Development Facilitation Team (DHO) – Review Comments

Project No: PR-2022-006935 Date: 12/06/2023 Agenda Item: 12 Zone Atlas Page: G-21

Application For: SD-2023-00191/SD-2023-00192/SD-2023-00193/SD-2023-00194/SD-2023-00210 – Vacation of Public Easements (3) and portion of one ROW/Preliminary Plat

SUBJECT: Vacation of Right of Way, Vacation of Easement, Preliminary Plat

**PRELIMINARY PLAT**  
**Lots 1A thru 13A**  
**Juan Tabo Business Park**

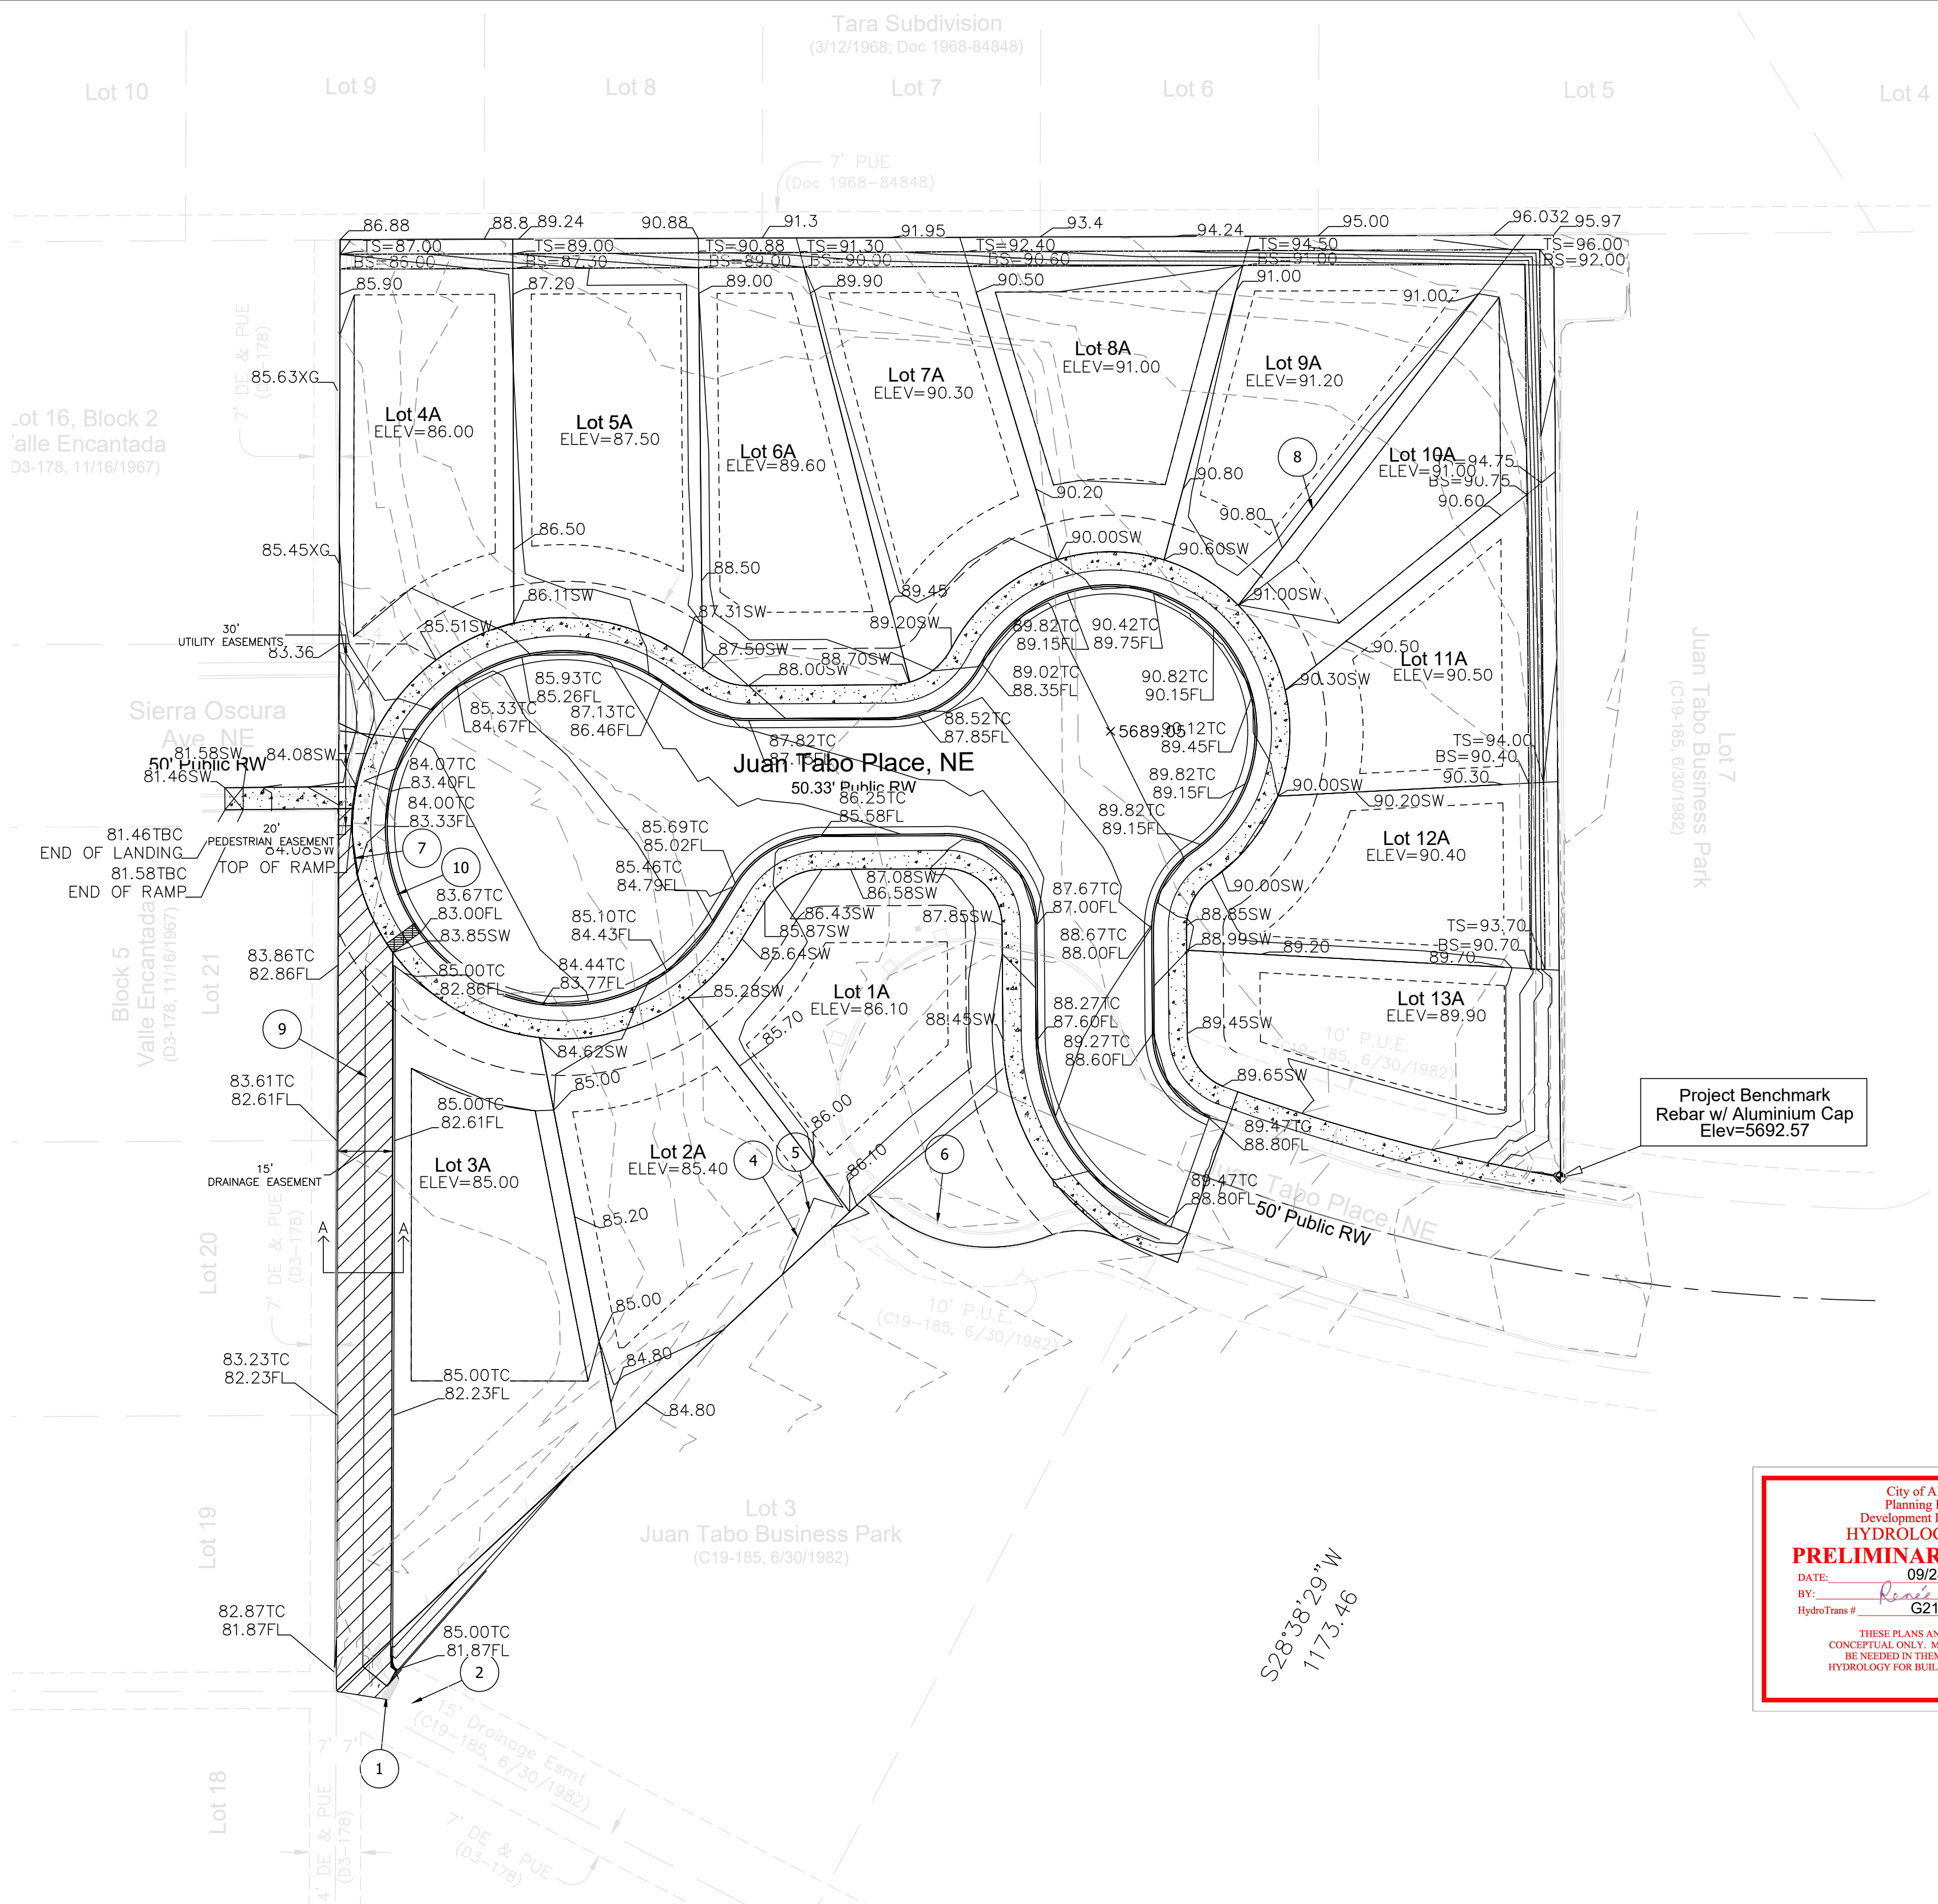
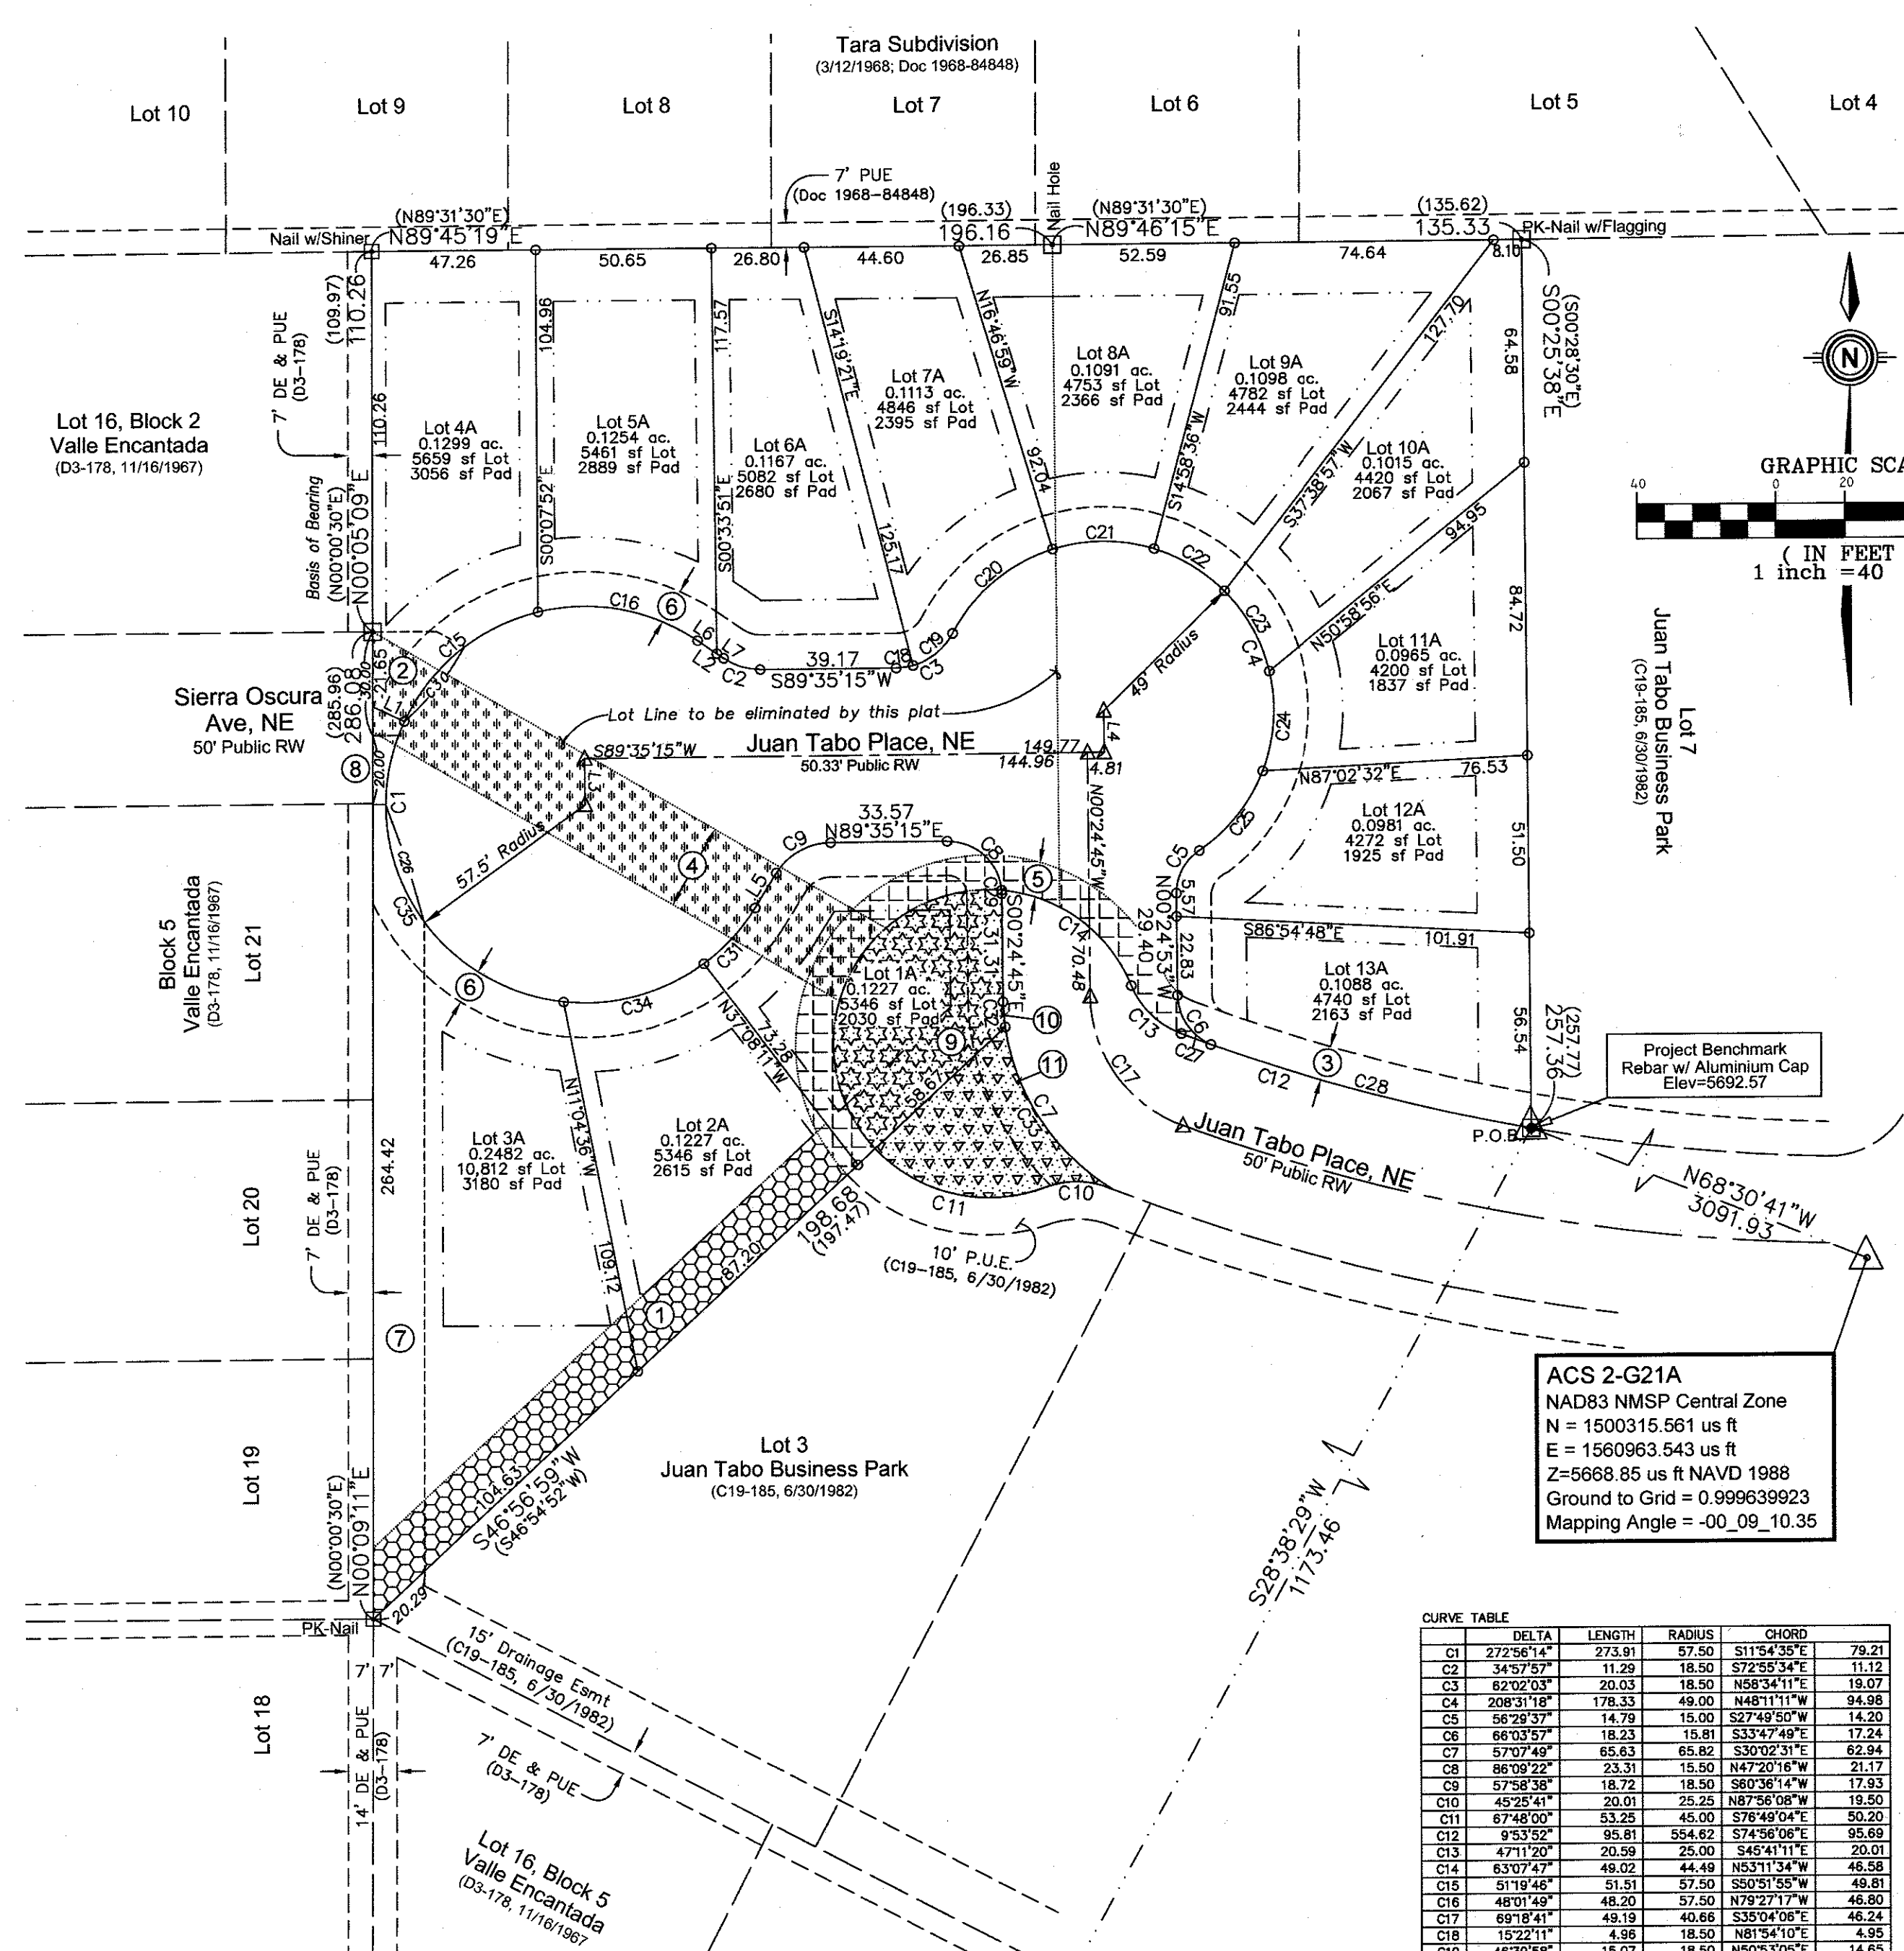
1. Vacation of easement and right-of-way is currently over operational water and sanitary sewer lines with existing services upstream from this site.
 - a. WUA is unable to vacate the easements and ROW without the lines being rerouted.
 - b. This will require a two-step process such that the easements and vacated ROW will be release by obtain a new maintenance easement over the live lines, which is filed immediate after filing plat.
 - c. The new maintenance easement will be vacated after water and sewer lines are rerouted and accepted by WUA in the new ROW.
2. Request that WUA utilities be in ROW or HOA tract, not easements. Side lot easements are not acceptable.
3. An infrastructure list with financial guarantee or construction completed and infrastructure accepted will be required prior to final plat signature.

1. No objection to the vacations.
2. For both existing portions and proposed portions, Juan Tabo Pl. is considered a local street and requires 5' sidewalks and 4-6' landscape buffers. Show cross-sections to ensure it will be located within right-of-way, and dedicate any right-of-way as necessary. Your current drawings show sidewalk and buffer but there are no dimensions and you have not provided an infrastructure list. All infrastructure shall be placed onto an infrastructure list and be reviewed through the work order process.
